Application No: EP/25/21/HH
Site Address: Netherby 59A Sea Lane East Preston BN16 1ND
Description of works: Erection of front and rear extensions, garage conversion and revised internal layout.

Thank you for your internet representation made on 22nd April 2021 which has been recorded as an objection with the comments as follows:

20/111	PL/02	B
PROJECT NUMBER:	DRAWING NUMBER:	REVISION:

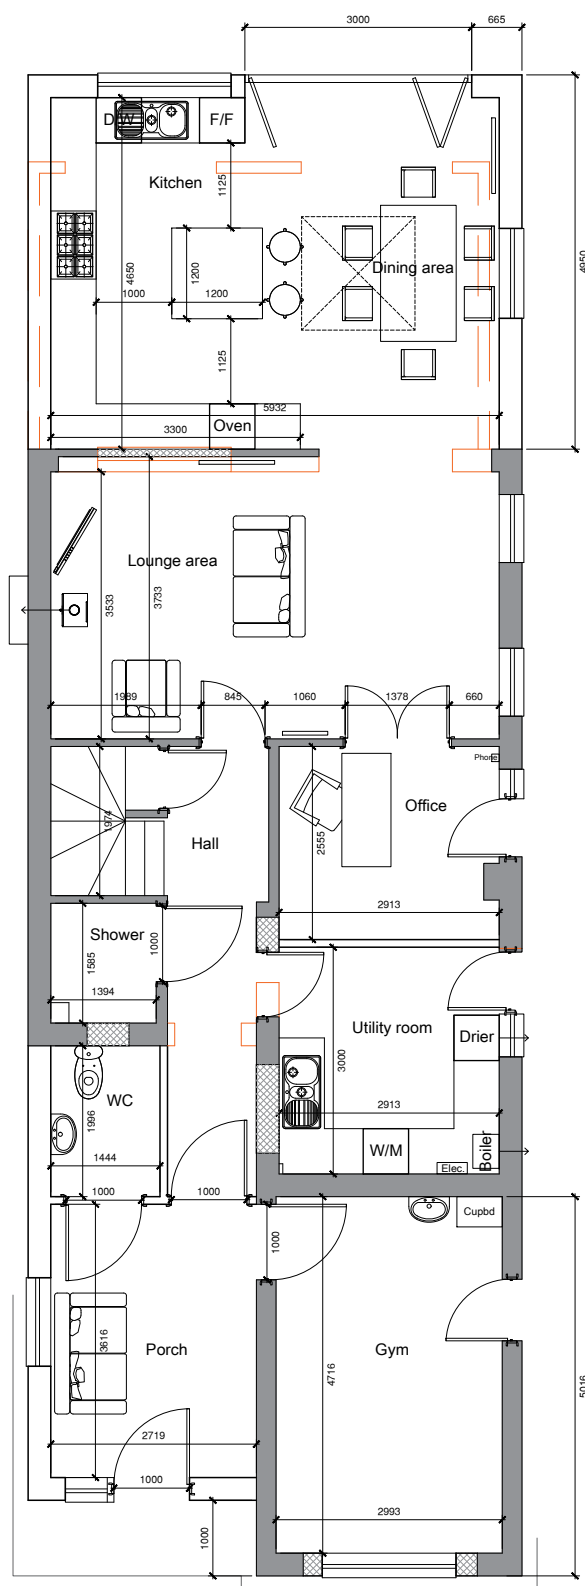
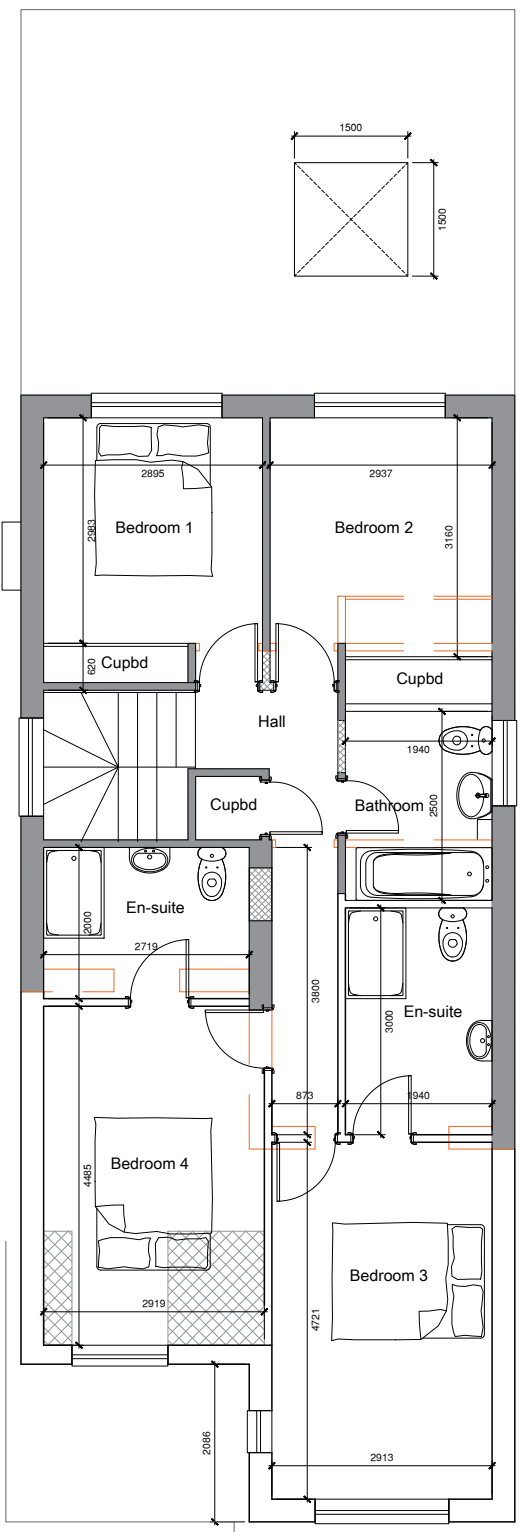
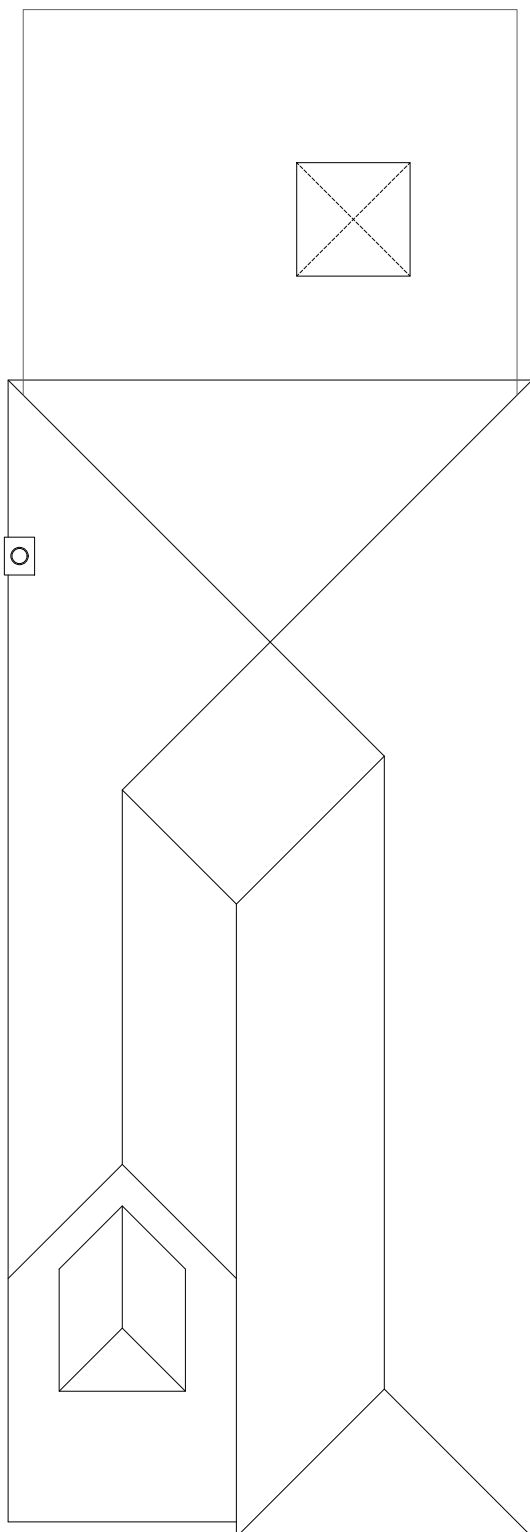
- 1) The rear single storey extension is considered acceptable.
- 2) The proposed front extension however by reason of its size and proximity to site boundaries is thought an overdevelopment of this plot and detrimental to the neighbourhood and to us as neighbours.

- 3) The front extension will take light away from our building, particularly our front room, our lounge.
- 4) The proposed ground floor north facing porch window interferes with our privacy, is unnecessary and should be omitted. If permission is given it should be for obscure glazing and a fixed sash.

- 5) The front first floor extension, over the existing garage, north facing window interferes with our privacy, is unnecessary and should be omitted. If permission is given it should be for obscure glazing and a fixed sash.

- 6) The loss of a parking space and a garage is significant in this area particularly having regard to the applicant's business use of these premises. We feel a parking plan should be provided in order to demonstrate there is sufficient parking for the property. It was a 3 bedroom property with 2 or 3 parking spaces and a garage and now they are proposing a minimum 4 bedroom property with 1 or 2 parking spaces and no garage.
